# PLANNING AMENDMENT

| <b>SITE ADDRESS DETAILS</b><br>136 Roman Bank, Spalding PE11 2HR                                                                   |  |                                                                                                                                                     |  |
| <b>CURRENT APPLICATION NO:</b><br>This amendment cannot be considered unless<br>the relevant reference is stated.                  |  | H16-0653-23                                                                                                                                         |  |

| <b>FULL DESCRIPTION OF DEVELOPMENT OF<br/>CURRENT APPLICATION THAT THIS<br/>AMENDMENT RELATES TO</b>                                                                                              | Change of use from house in multiple occupation to<br>two flats - Retrospective       |                    |

JOB TITLE : 136 Roman Bank, Spalding PE11 2HR	
DWG TITLE : As Built Plans	
DWG. NO. : 641-02-B	
SCALE : As shown @ A3 Do not scale from drawing	
DATE : 01/08/2023	
STATUS : PLANNING	
DRAWN BY : AK	CHECKED BY : NF
© CLAYTON ARCHITECTURE LIMITED. Tel: 01435 589485 E: info@claytonarchitecture.co.uk

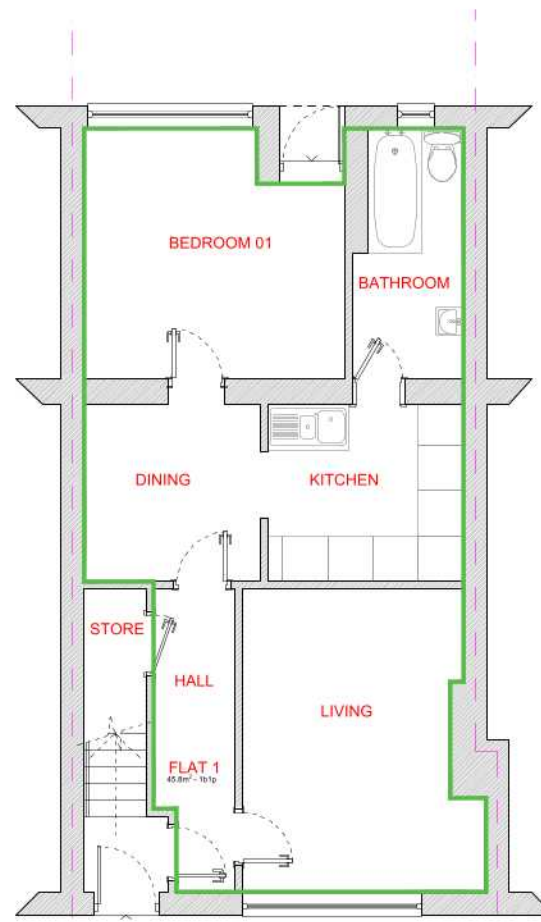
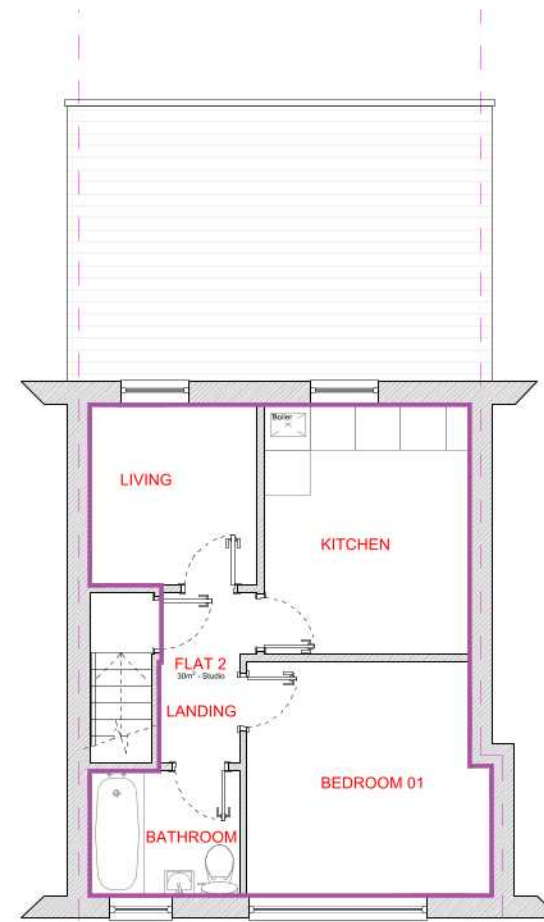
| State details of amendments proposed.<br>(Give a full detailed list of the changes; and also<br>mark these clearly on the accompanying plans.<br>Only the changes listed here will be considered) | Unit GIA's added to plans and Flood Risk Assessment<br>added to supporting documents. |                    |
